WELWYN HATFIELD COUNCIL – DEVELOPMENT CONTROL
DELEGATED REPORT

APPLICATION No:	<u>N6/2007/137/OP</u>
LOCATION:	<u>Land at Bridge Road East and Bessemer Road,</u> <u>WGC</u>
PROPOSAL:	<u>Outline Application for Mixed Use Development,</u> <u>Including Employment (B1) and Hotel and</u> <u>Conference Centre (C1)</u>

Drawing Title
**PROPOSED
SITE PLAN**

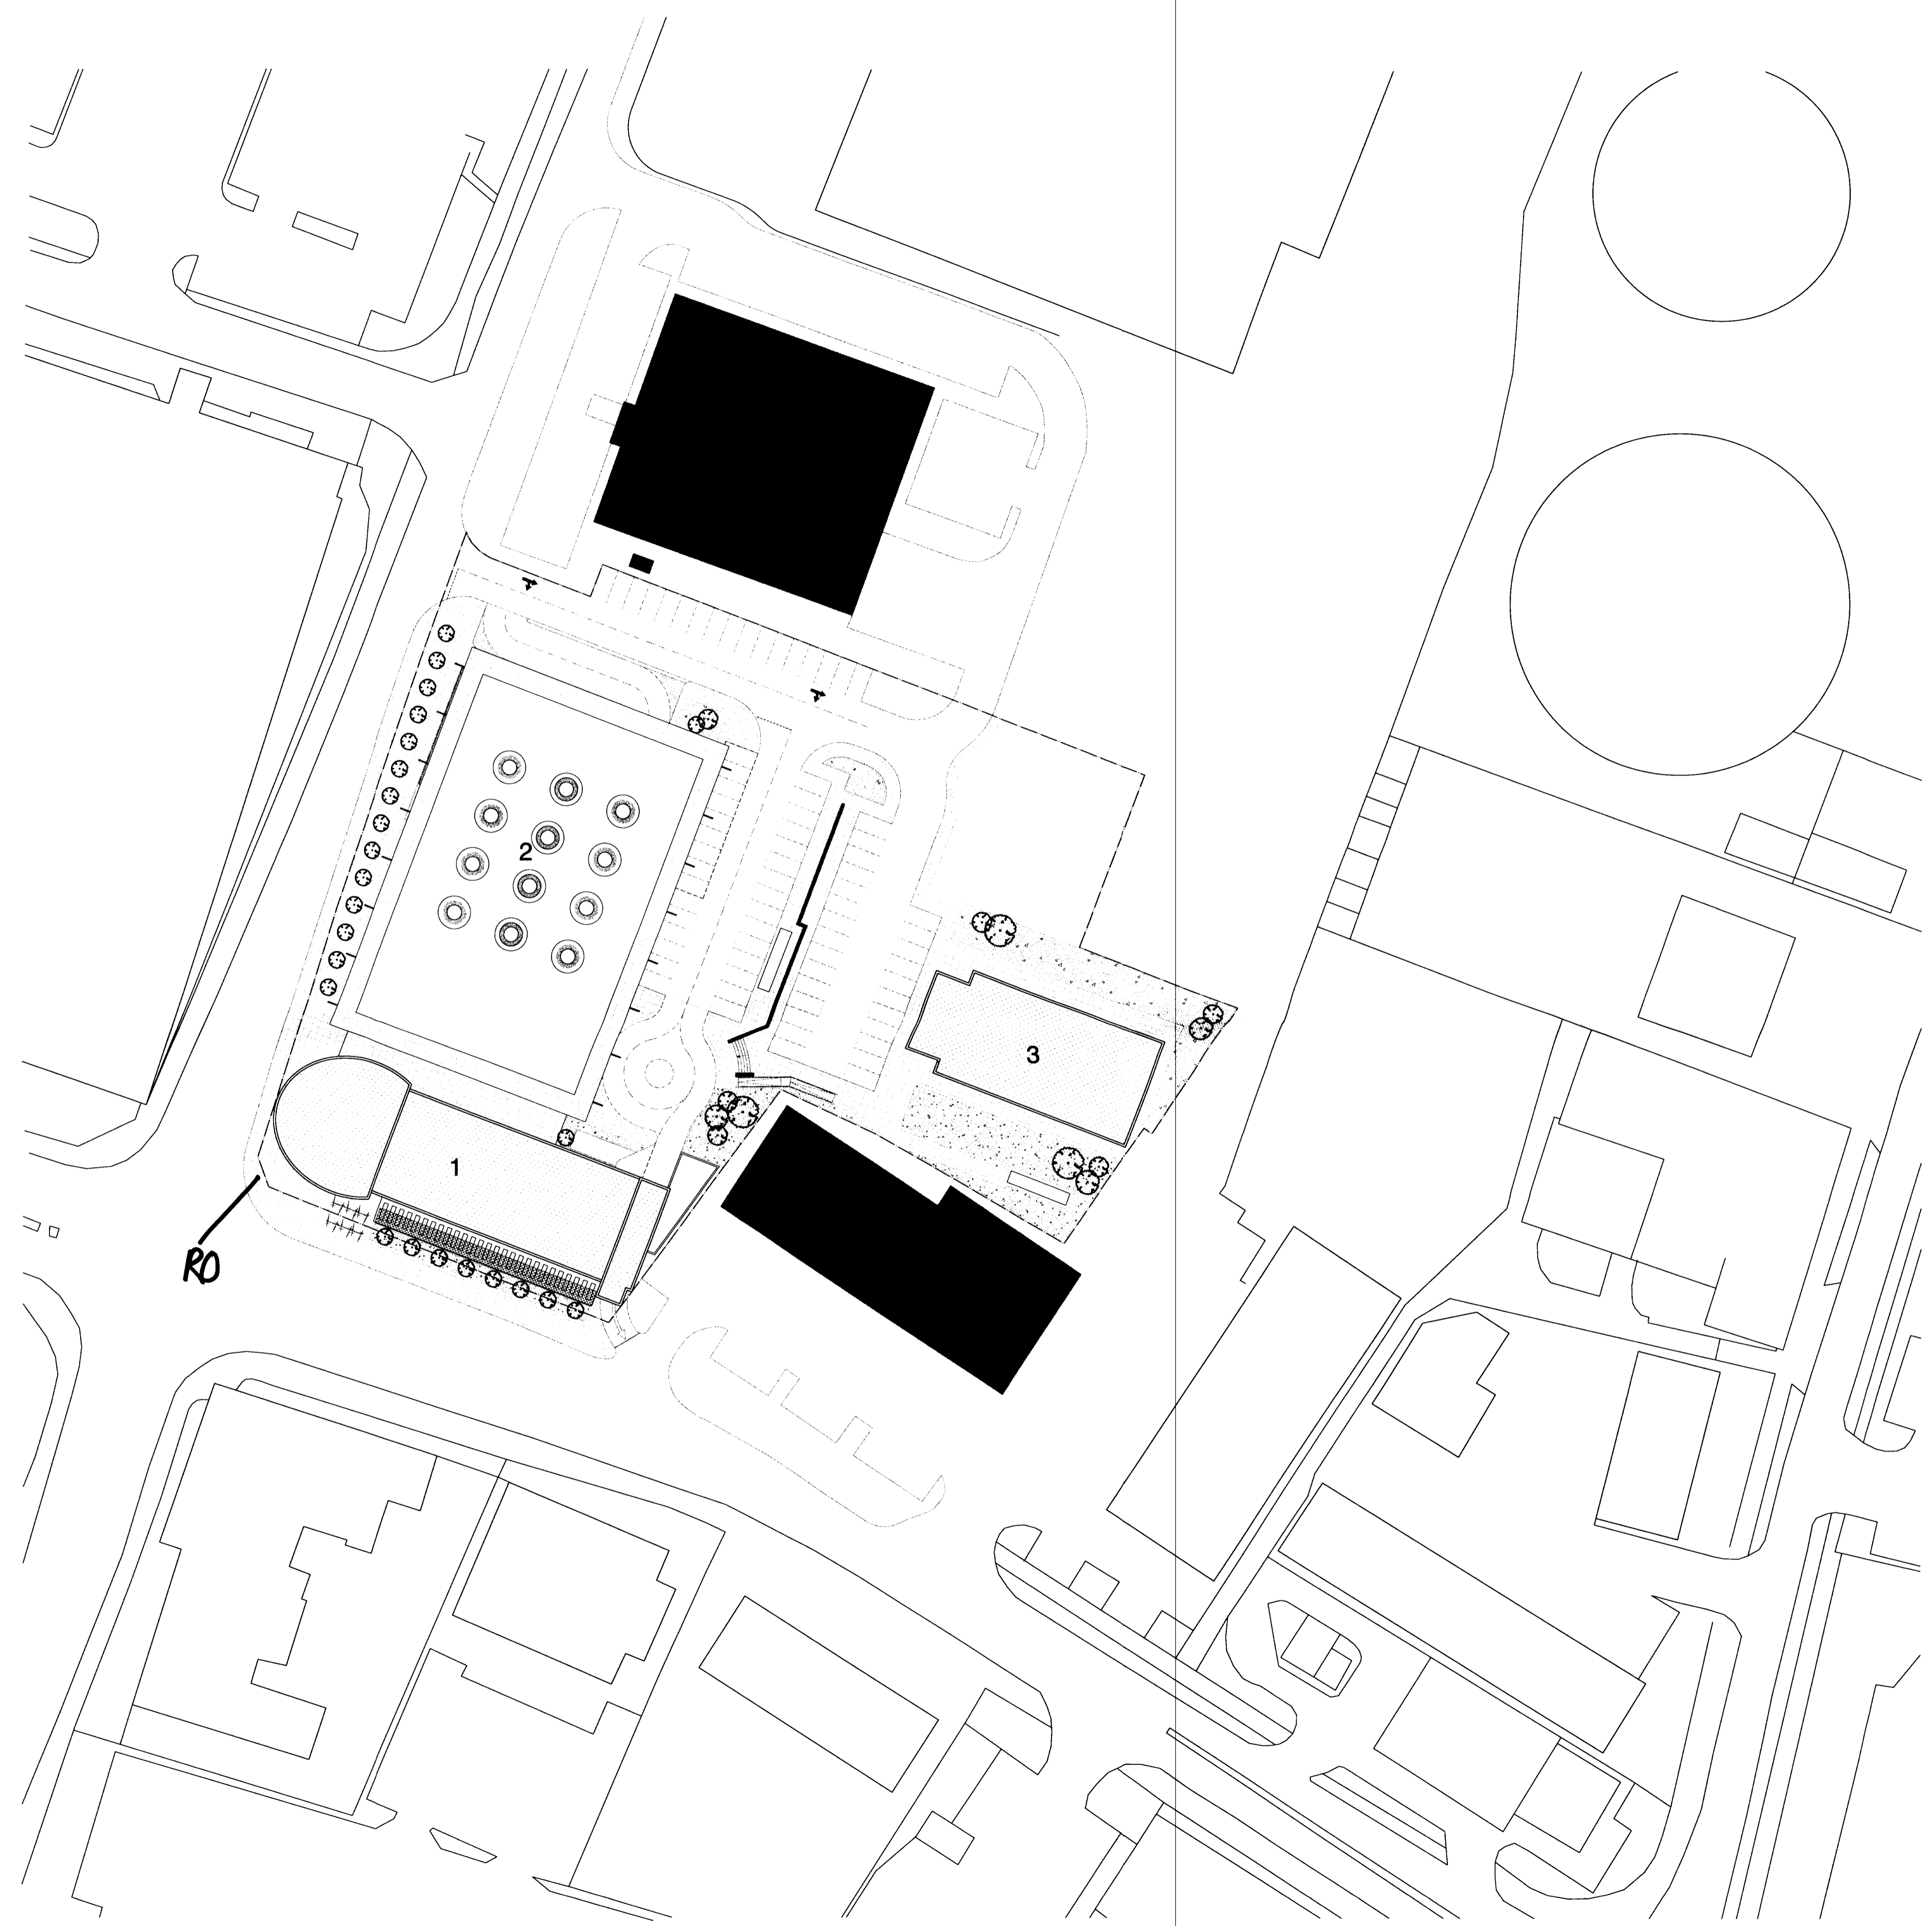
2) With regards to the impact of the proposed development on the character and appearance of the street scene the main issue to consider is the layout of the proposed development in relation to that of adjoining buildings, topography and public views and vistas. It is acknowledged that the proposal is in outline, however the applicant has requested that means of access and siting be considered at this stage. The previous application was submitted prior to the changes to the outline planning process as stipulated in Circular 01/2006. The applicant has requested again for this application that Siting (Layout) and Means of Access (Access) are considered at this stage and that the other reserved matters are scale, appearance and landscaping. Information has also been submitted detailing the use, amount of development, scale parameters, indicative access points and an indicative layout (although this is not indicated as being such on the submitted plans).

The new access onto Bessemer Road is approximately 85m from the signal controlled junction of Bessemer Road and Bridge Road. According to the transport statement queue, lengths of up to 15 vehicles were observed during the morning peak. These queues could extend up to the proposed access and the applicant has failed to demonstrate any measures proposed to ensure that this access is kept free so that any traffic trying to turn right into the site from the south does not delay traffic on Bessemer Road. In addition, HCC have expressed concerns regarding the proposed layout as it could have an impact on the surrounding highway network. The entrance to the undercroft car park is close to the new junction from Bessemer Road. Cars queuing to exit the site onto Bessemer Road will block the access to this car park, and this could result in cars not be able to enter the site from Bessemer Road thus affecting the flow of traffic on Bessemer Road.

The latest information received shows that the proposed traffic generated by the development will be much greater than that estimated in the Traffic Assessment and will have a material impact on the flow on Bessemer Road and that the movements in and out of the new junction (180 vehicle movements in and out in the am peak) will interfere with the flow of traffic on Bessemer Road and therefore the same concerns apply. In addition to this, the proposed exit onto Bridge Road East has been re-assessed and it is not clear from the plans submitted how this exit will work with the existing access to the adjoining property, this is a potential point of conflict between vehicles using this exit and those entering the adjoining property. Although the exit has been put at an angle to the existing carriageway it would also be possible for smaller vehicles to try and turn right here, which would occur due to the delays that would be experienced exiting onto Bessemer Road. Accordingly, the traffic arising from the proposed development would be likely to interfere with the free and safe flow of traffic on the highway network and the slowing and turning of vehicles associated with the use of the access would lead to conflict and interference with the free flow of traffic on the highway and be detrimental to highway safety. In this respect, the proposal fails to overcome the previous reason for refusal and would have a detrimental impact on the safe and efficient operation of the highway.

It is noted that servicing arrangements for the conference centre involve using nine parking bays. The transport statement expects these deliveries to be infrequent and that these bays would be temporarily suspended. However, the report also states that these bays are for use by the business units rather than by the conference centre so there may be a conflict of interest over the use of these bays for servicing.

Project
**Land at Bridge Road East
& Bessemer Road**
Drawing Title
UNDERCROFT PLAN

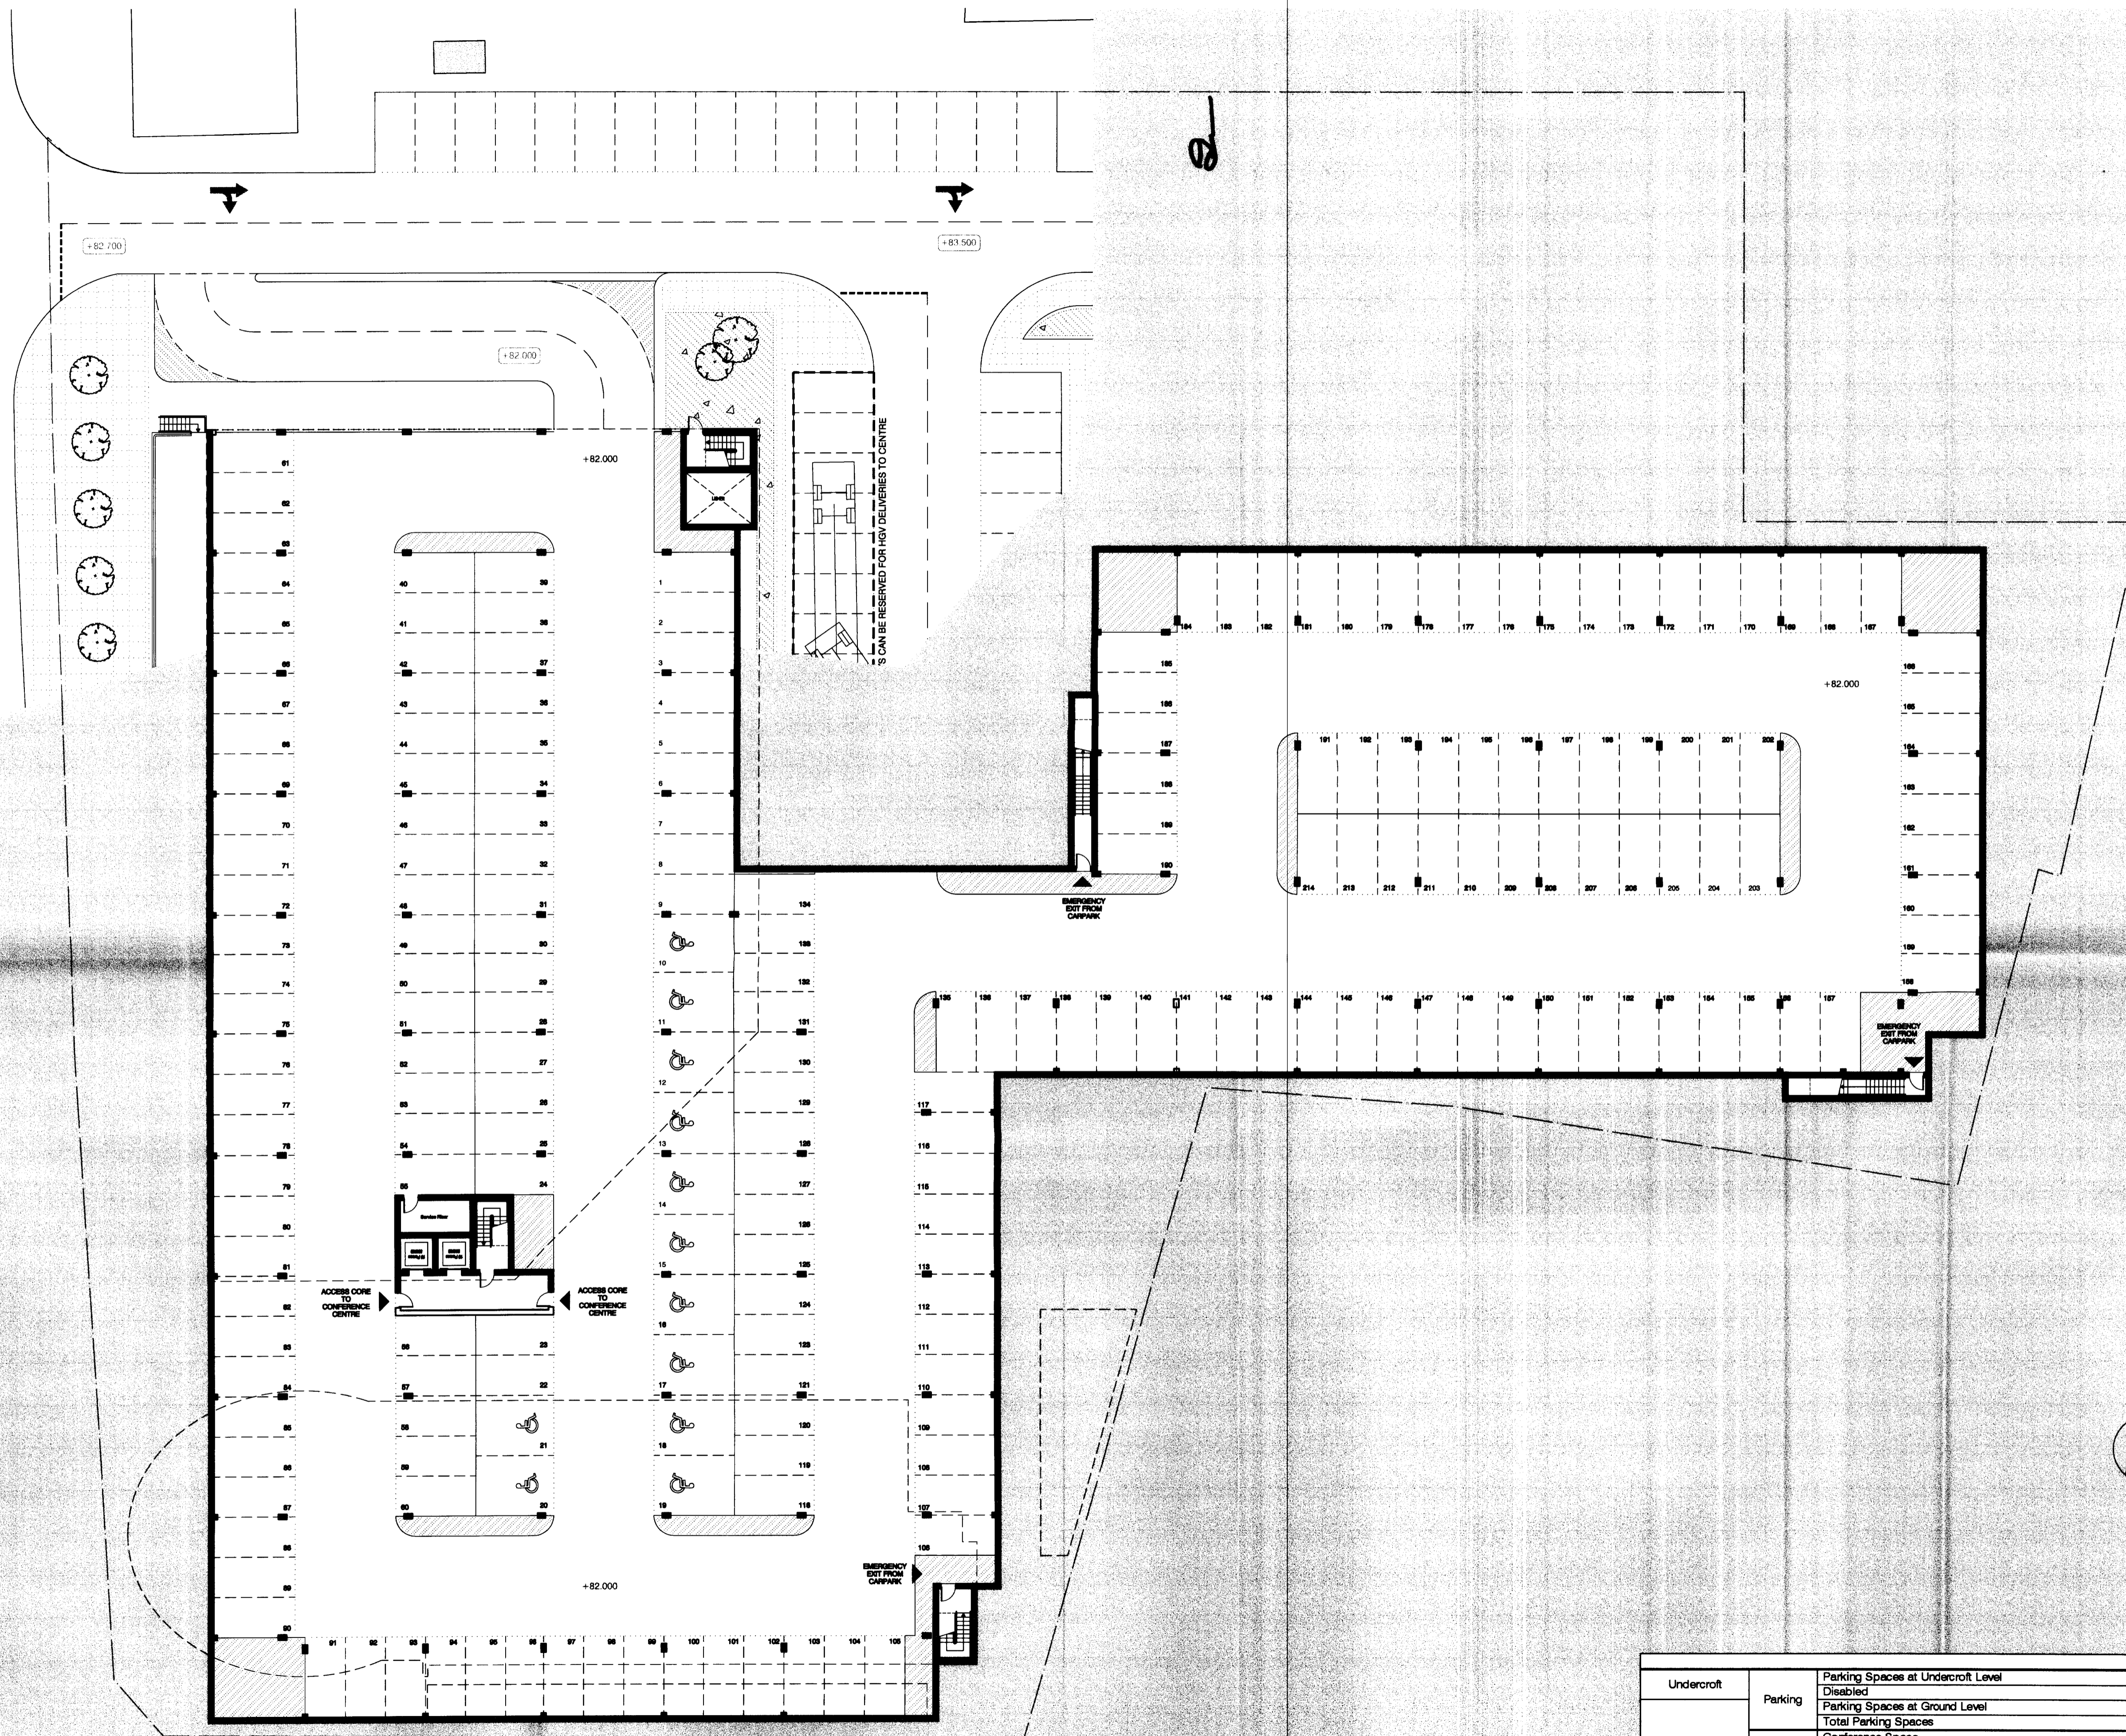
Turning to the proposed car parking provision It is proposed to provide 56 car parking spaces for the office element on the surface level and 226 spaces in the undercroft for the hotel and conference centre giving a total of 282 spaces. The submitted Transport Statement indicates that a maximum of 582 spaces would be required under the adopted standards.

However, this must relate to the previous development as the floor space of the accommodation has been reduced significantly and under the adopted parking standards the requirement for the office part of the development would be a maximum of 70 spaces (based on one spaces per 30sqm gfa). The conference centre is classed as a D1 use and at 1675sqm; it would require 1 space per 9sqm or 1 space per three fixed seats. As the number of seats are not know it is reasonable to use the sqm and therefore the conference centre requires a maximum of 186 spaces plus three spaces for every four staff members. In addition, the hotel element requires approximately 64 spaces for the bedrooms in addition to spaces for the dining area, bar area and 2 spaces per 3 members of staff. Although these details are unknown, the plans indicate that there is 353sqm 'front of house' area with probably half of that being for a dining/bar area, resulting in a requirement for a further 40 spaces for this element alone under the ADP. Given the end user of the hotel is not know, it is difficult to calculate the exact requirements.

The site falls within Zone 3 where a reduction to 50-75% of the maximum can be applied. This zonal approach applies to urban areas only and it is appropriate to restrict car parking in town centre locations where there are opportunities to walk to shops and other services and the work location is within acceptable distance of a range of transport facilities. Using this zonal approach, it could be considered that approximately 175 – 260 spaces are required if 350 spaces is considered appropriate and if 400 spaces, 200 – 300 spaces are required. However, although they provision is within the 50-75% range, it has not been proven to the satisfaction of the local

planning authority and highway authority that the proposed car parking provision is acceptable at this outline stage and would not result in a level of on street car parking that would not be detrimental to highway safety.
